Project No. 21071

**Re: SUB22-002 (Design Built Homes Preliminary Short Subdivision)
Request for Information #1
4719 86th Ave SE**

This letter is provided as response to comments dated September 12, 2022. Each item has been carefully reviewed and considered and the following is a summary of how each item was addressed.

DRAWING: C2  
 SHEET: 2 OF 4

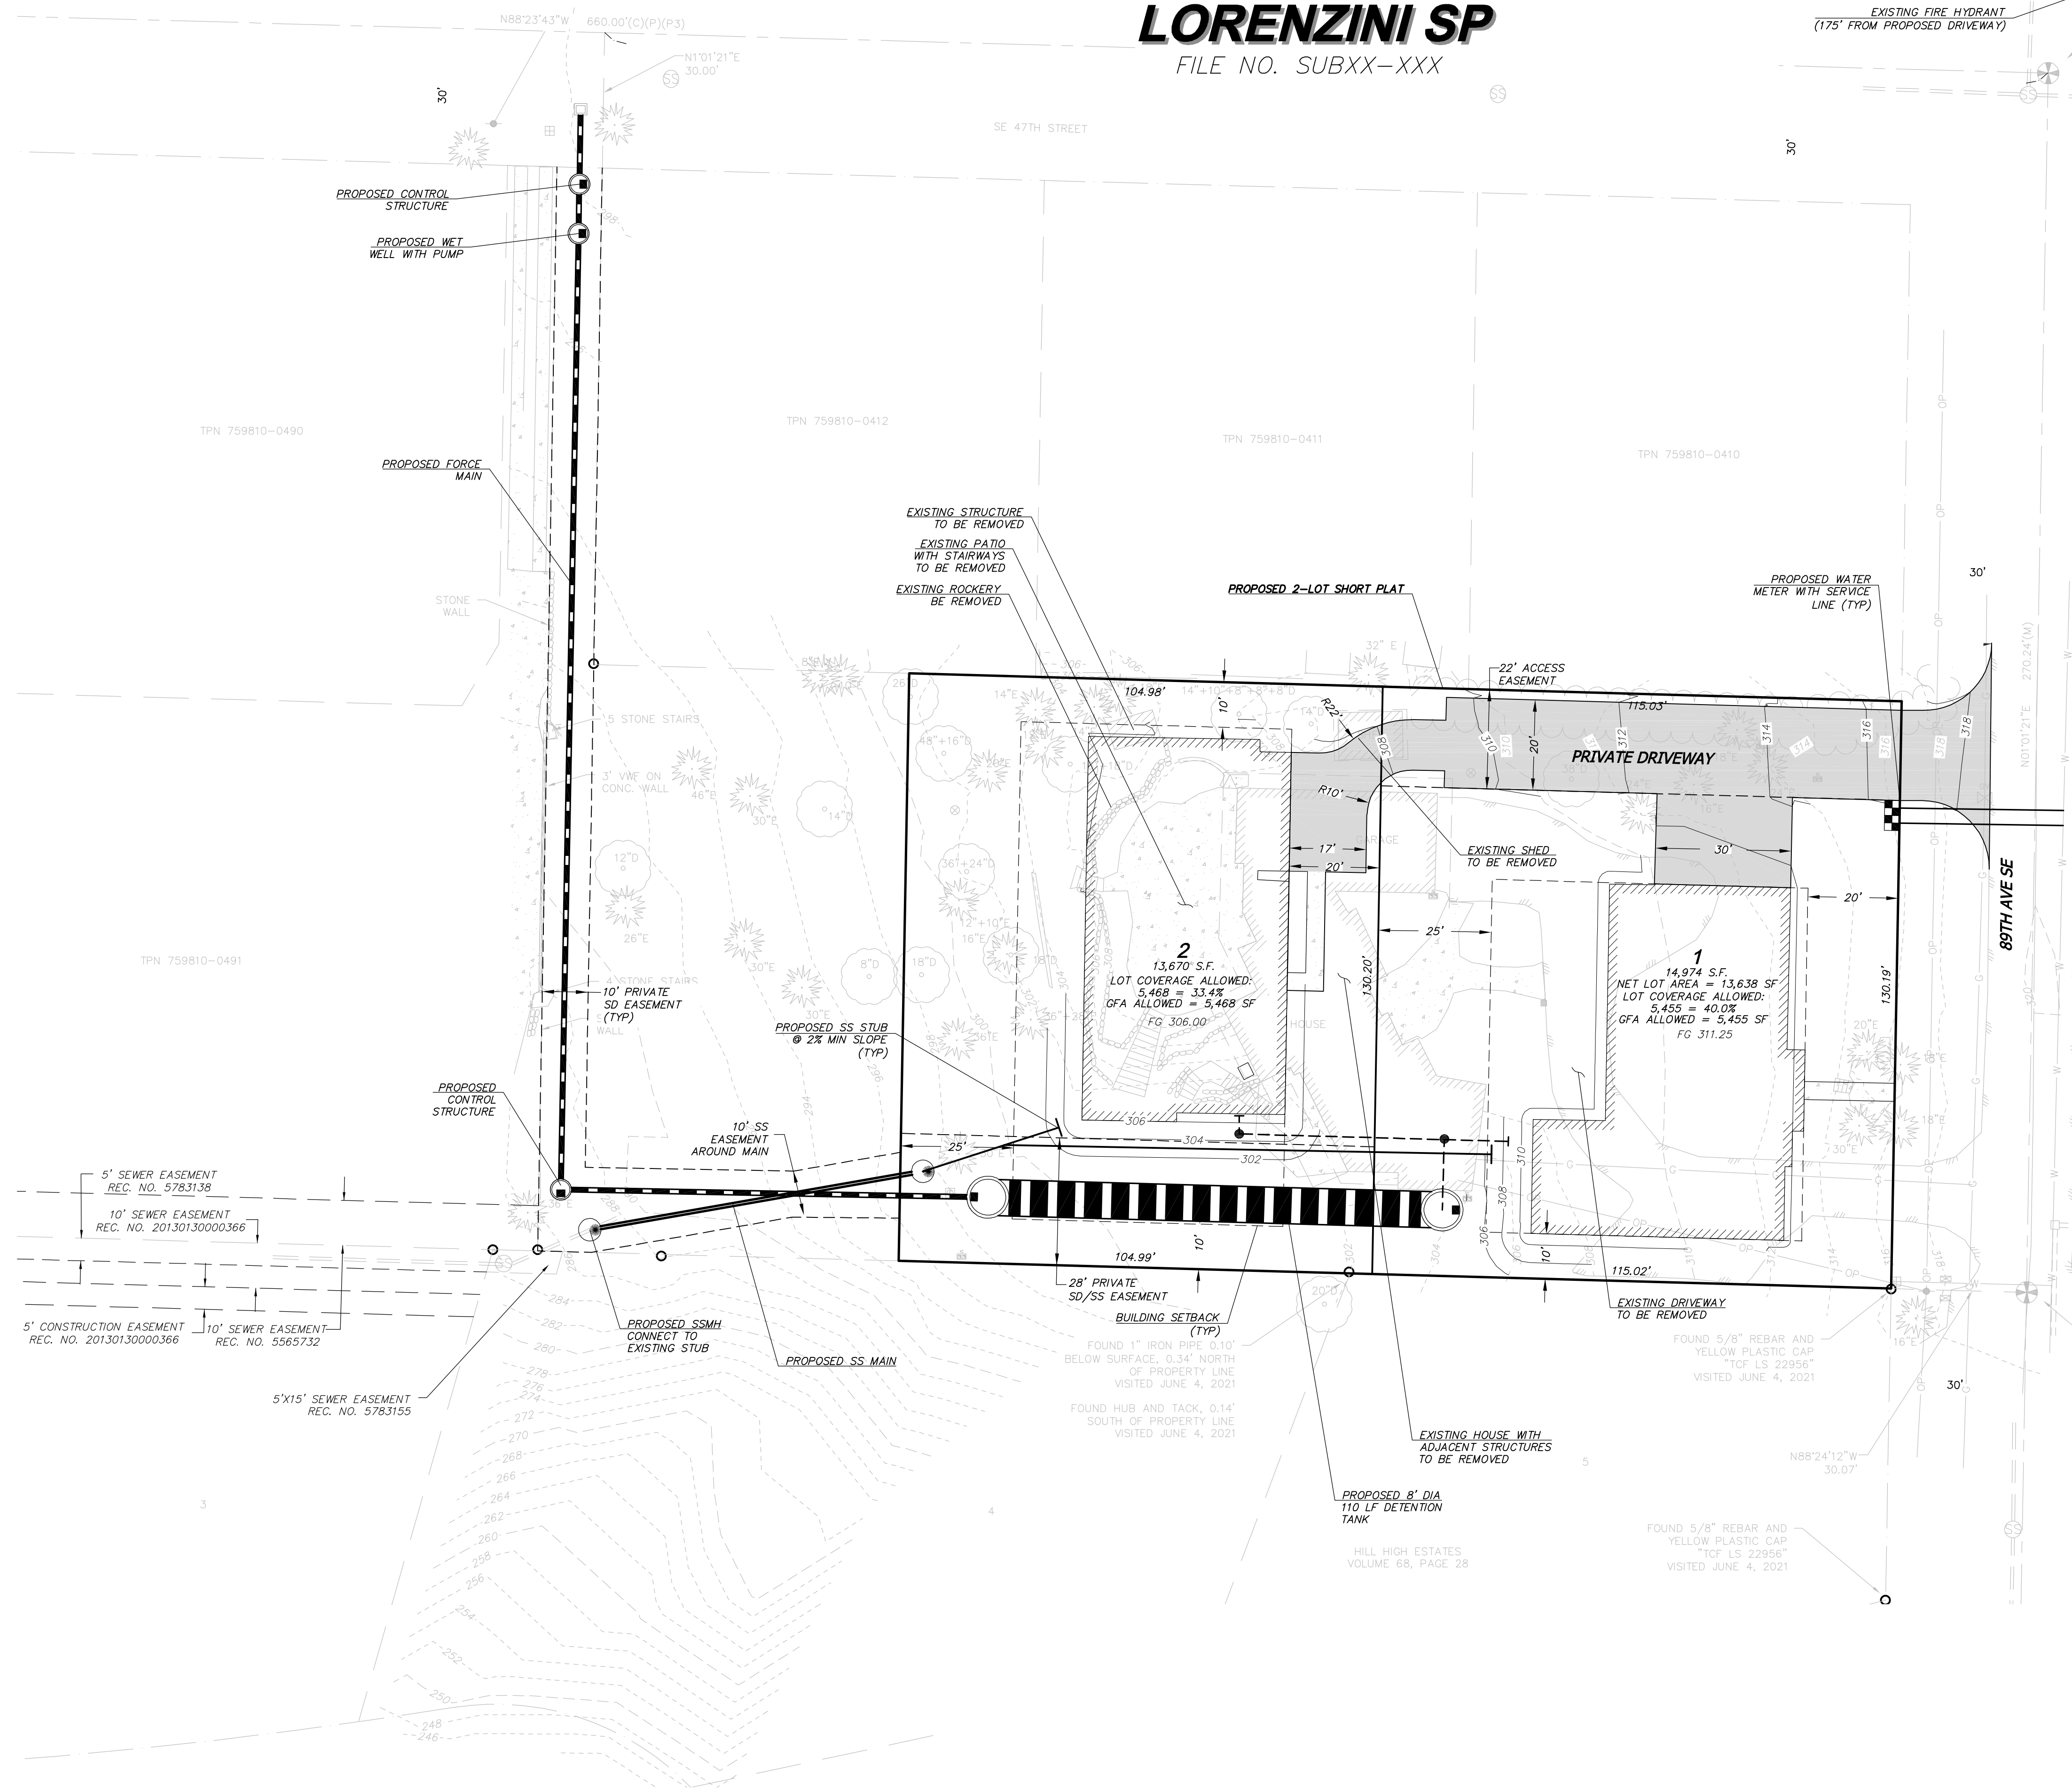
3. MICC 19.02.020(C)(1)(c)(i)((b)) states that for lots with a lot width of more than 90 feet, the sum of the side yards width shall be a width that is equal to at least 17% of the lot width. Based on the width of Lots 1 and 2 on the development plan set, the side yard setbacks for both lots would need to add up to approximately 22.13 feet. Please revise the side yard setbacks shown on the development plan set.

6. Please clearly distinguish if the 22-foot access easement on the north side of Lot 1 is private or public, existing or proposed, and for which lot the easement is benefiting.

8. The driveway width must be increased to 20 feet all of the way from Lot 1 to Lot 2, or within 150 feet of the furthest point from the City road.

Lot 2 side setback has been revised to be 12.13' at the southern property line. The setbacks now sum to 17% of the lot's width at 22.13'. Lot 1 complies.

The 22' access easement is a proposed private access easement to provide access to Lot 2. The label has been revised.

Distances are shown on the Site Plans to prove that the distance from the end of the 20' drive to the back corners of the Lot 2 building are less than 150 feet.

DRAWING: C3  
 SHEET: 3 OF 4

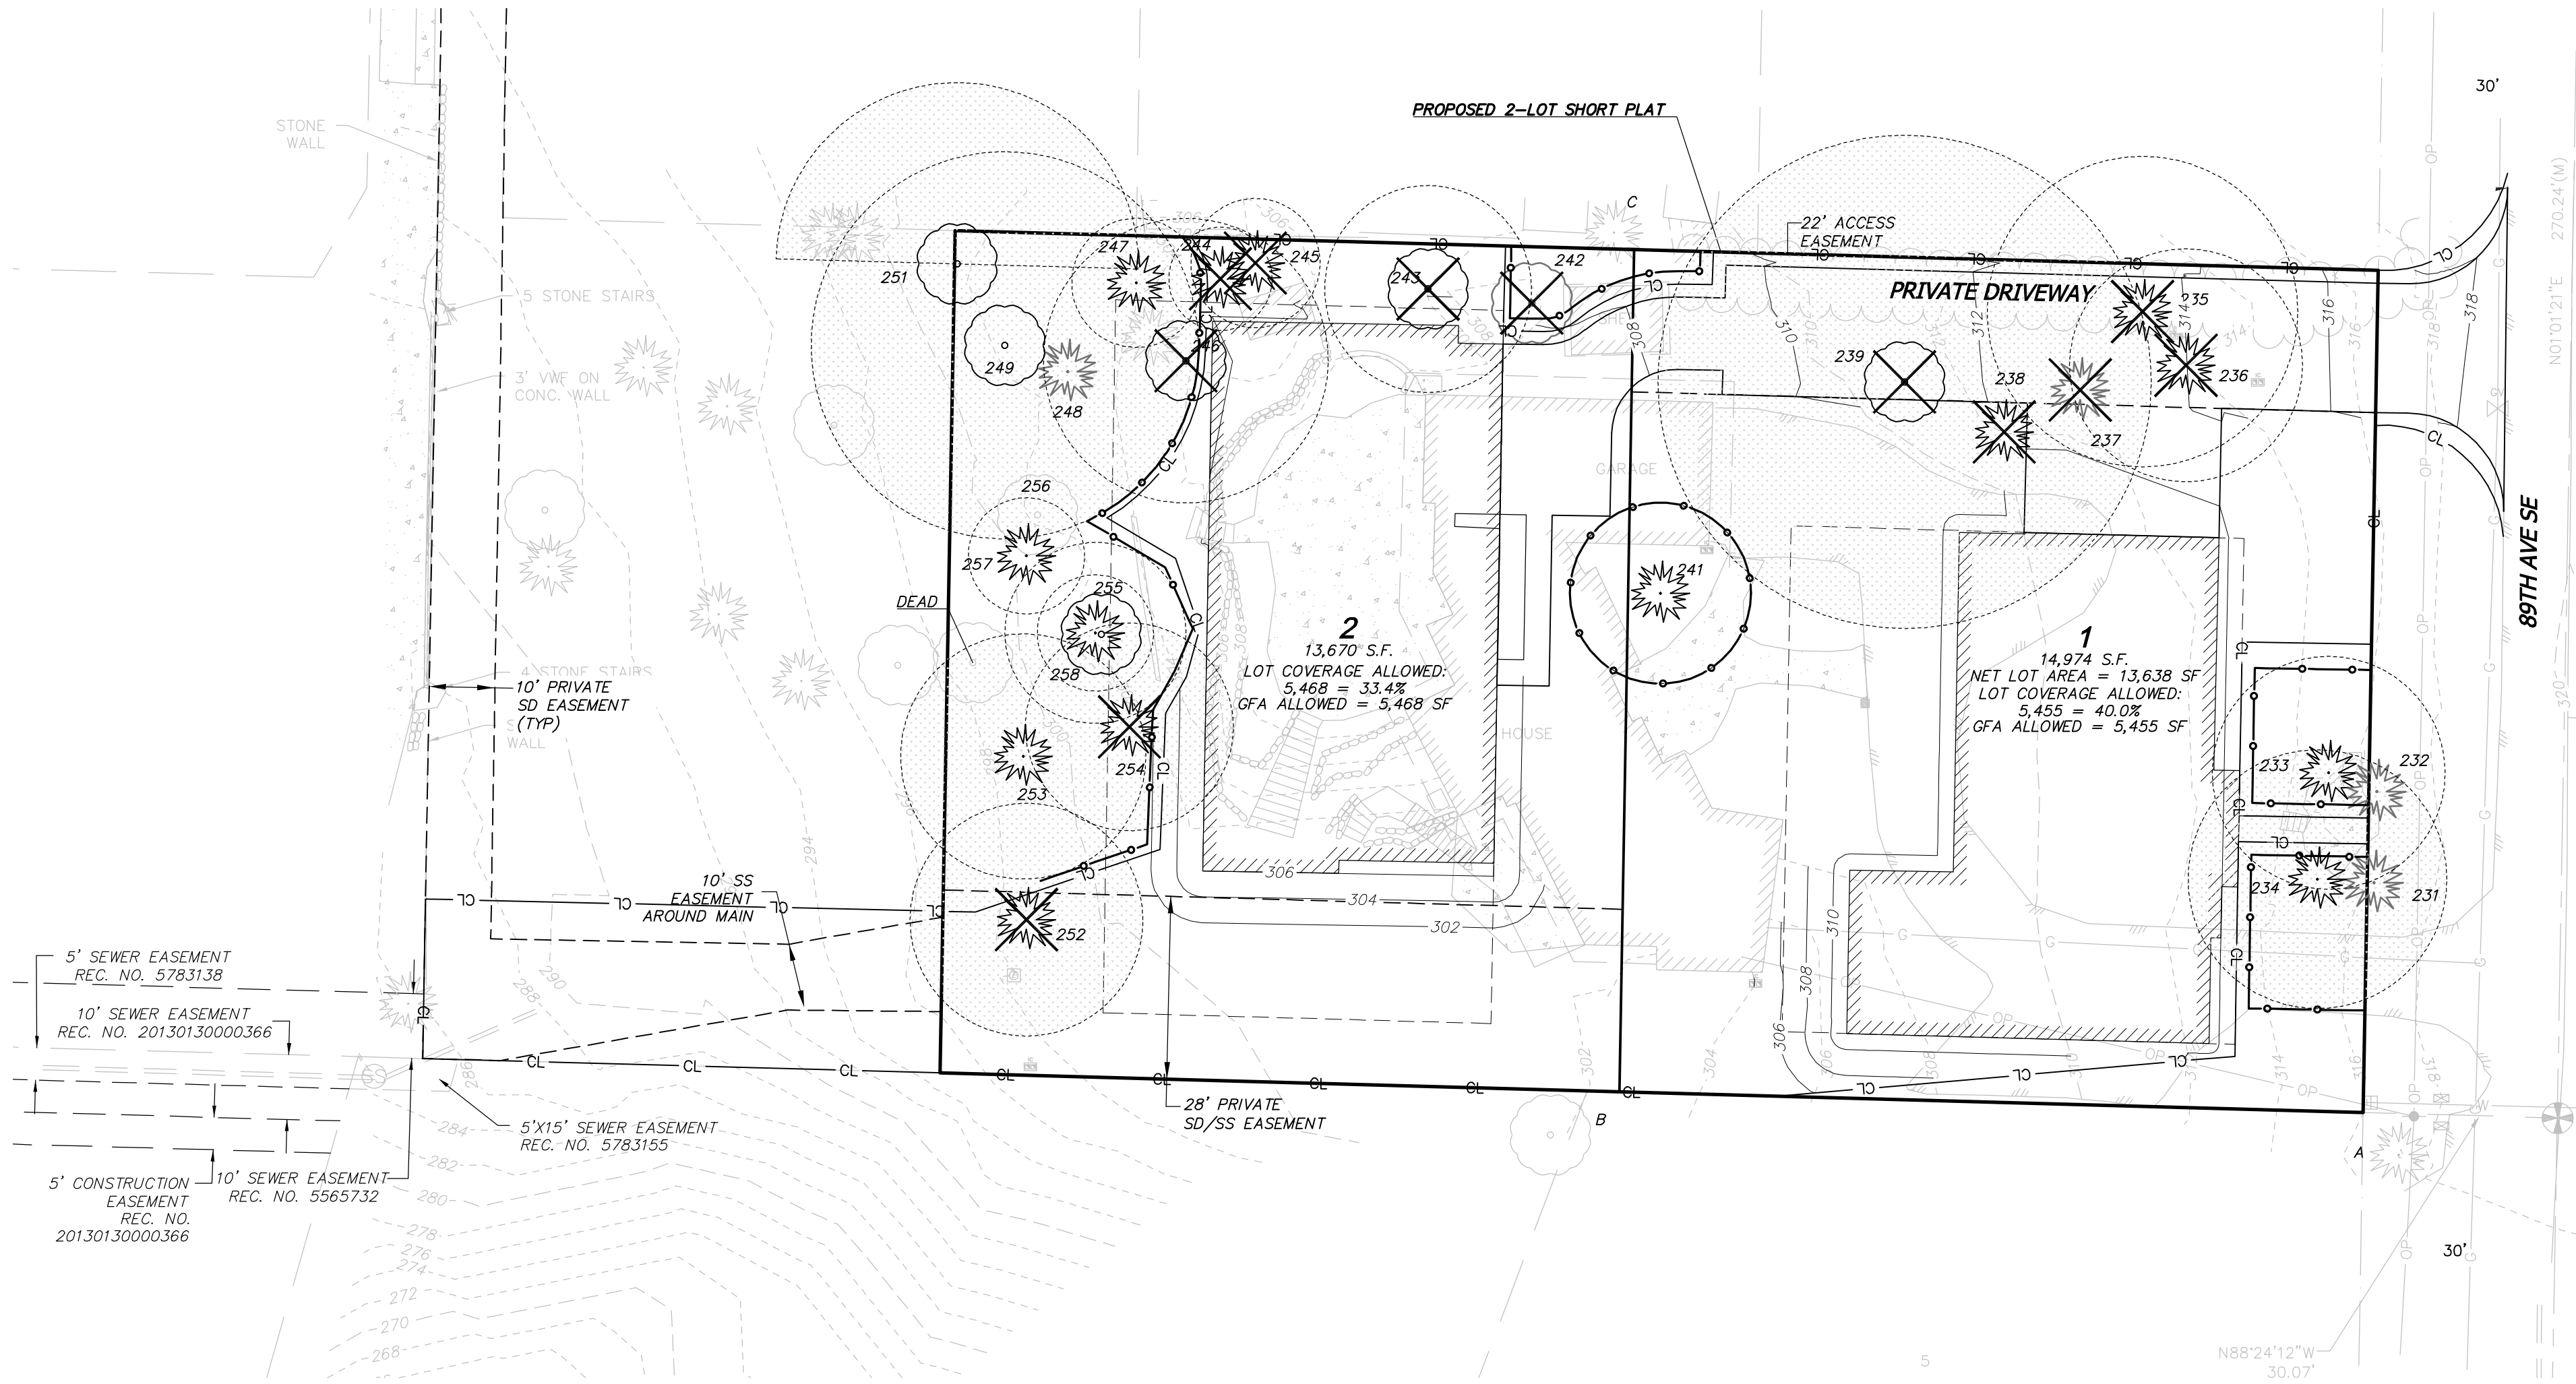
9. Please either move the building pad and over excavation of Lot 1 outside of the critical root zones of trees 231-234 or provide an air excavation analysis that demonstrates that these trees would not be damaged by the work. The analysis will need to call out specifics of the project design. Alternatively, these trees could be proposed to be removed if the minimum required number of regulated trees will be retained.

10. Trees 239 and 254 are exceptional in size and in fair condition. Please either protect the trees according to the arborist-given driplines or justify their removal of the trees under MICC 19.10.060(A)(3).

The building pads will remain as shown. An air excavation analysis will be provided to demonstrate that trees 231-234 will not be damaged during construction.

Tree 239 is located in the proposed private access easement which is required to provide a 20' width drive aisle from the existing roadway to Lot 2 per Fire Marshal.

Retention of tree 254 will prevent creation of a residential lot through a subdivision or short subdivision that is otherwise allowed by MICC 19.10
